H
LITTLEHAMPTON
HERITAGE
GROUP

LU/3/19/PL

Empty Supermarket Premises Avon Road Littlehampton BN17 6AT

East Elevation of Building 2

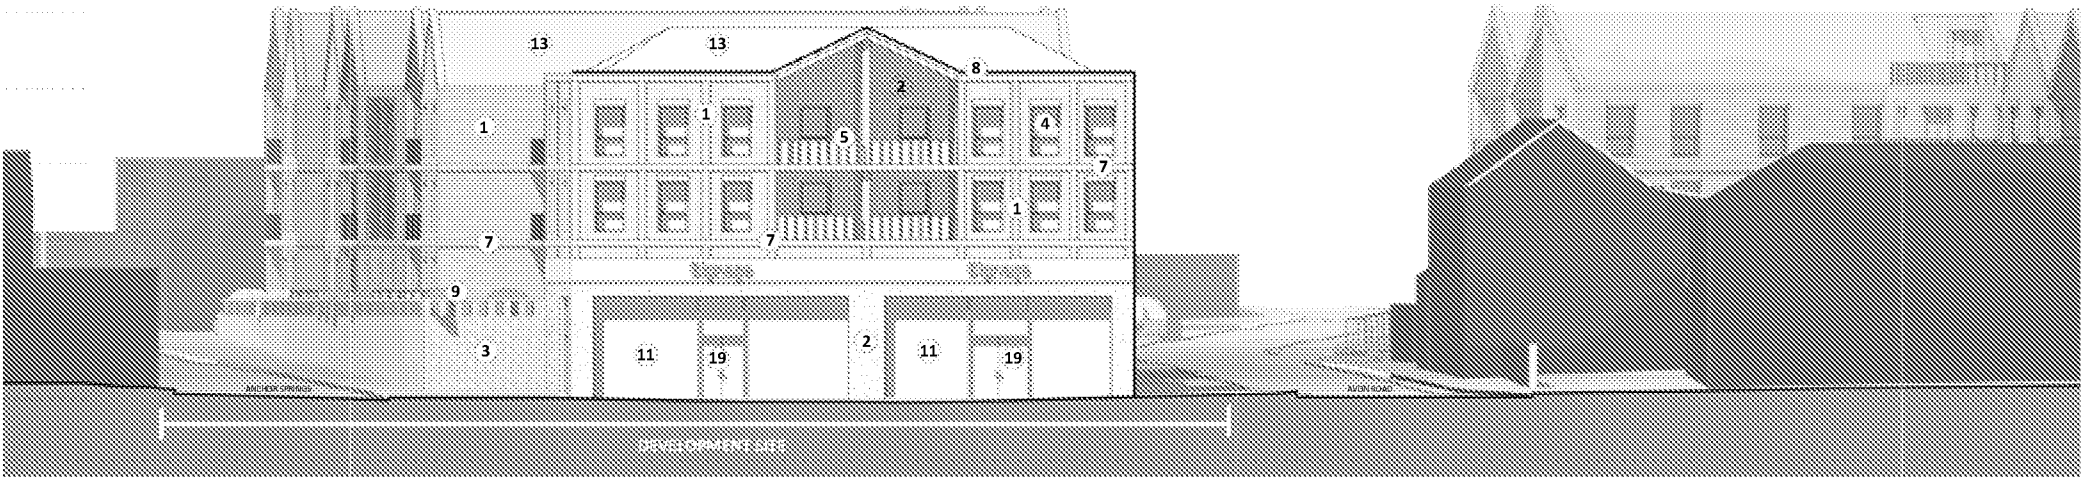
The position and glass fronted slab design of the shops is incongruous with any building they overlook. The Gratwick Arms development and the proximity to the Flint faced Flintstone Centre, should be considered as this looks directly onto them. Plus, for shops, there is no immediate parking nearby for deliveries and loading.

1.4 Building Height Analysis

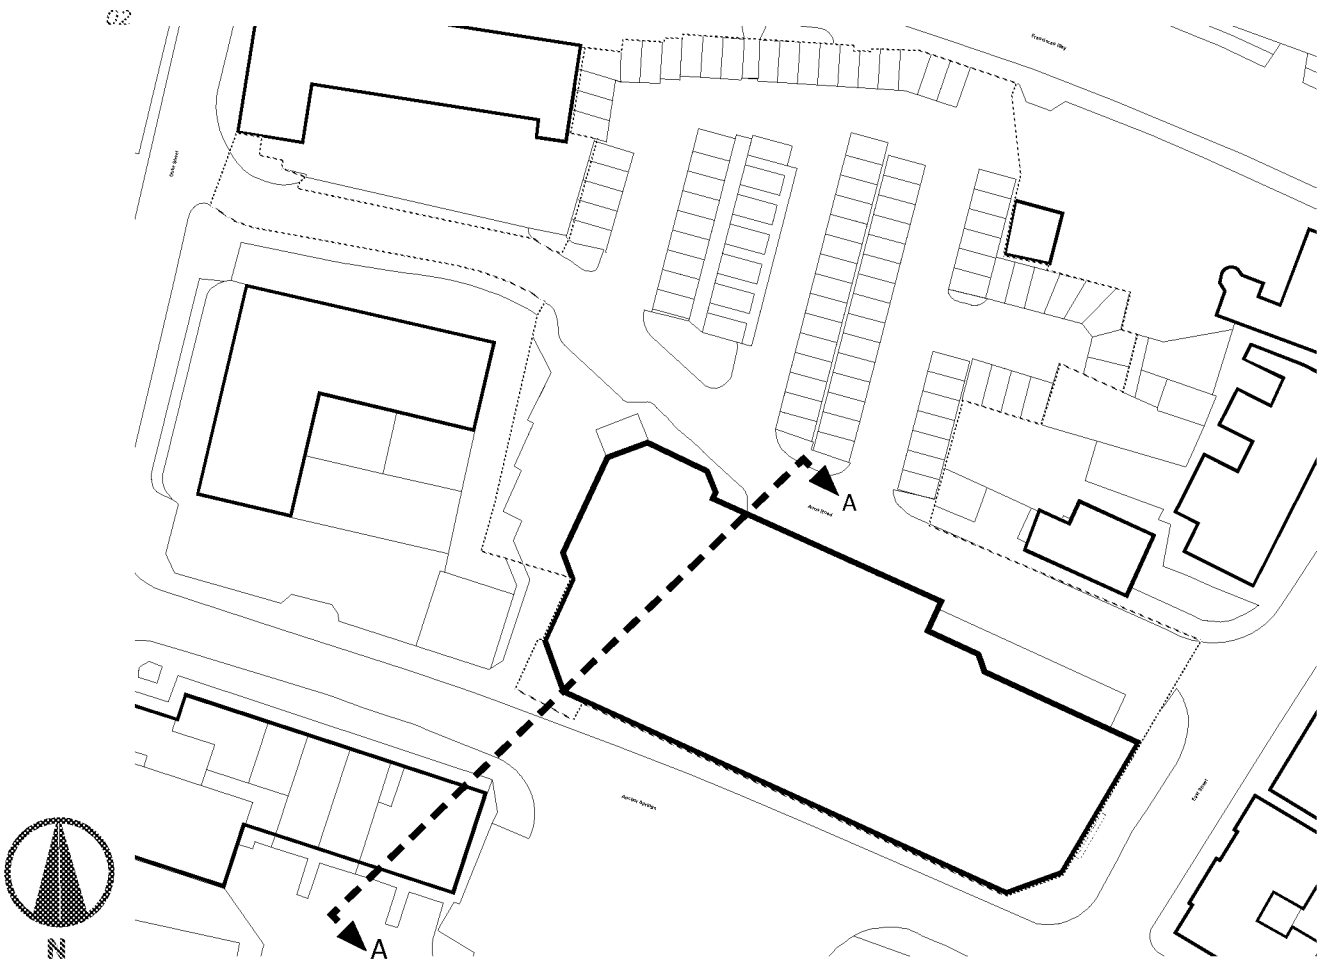
This proposal is on the immediate boundary of the East Street conservation area. We consider the creation of two large blocks of flats, at points higher than the existing supermarket building, to be at great odds with the characteristics of the area. Both in scale and design. It is likely to overwhelm it.
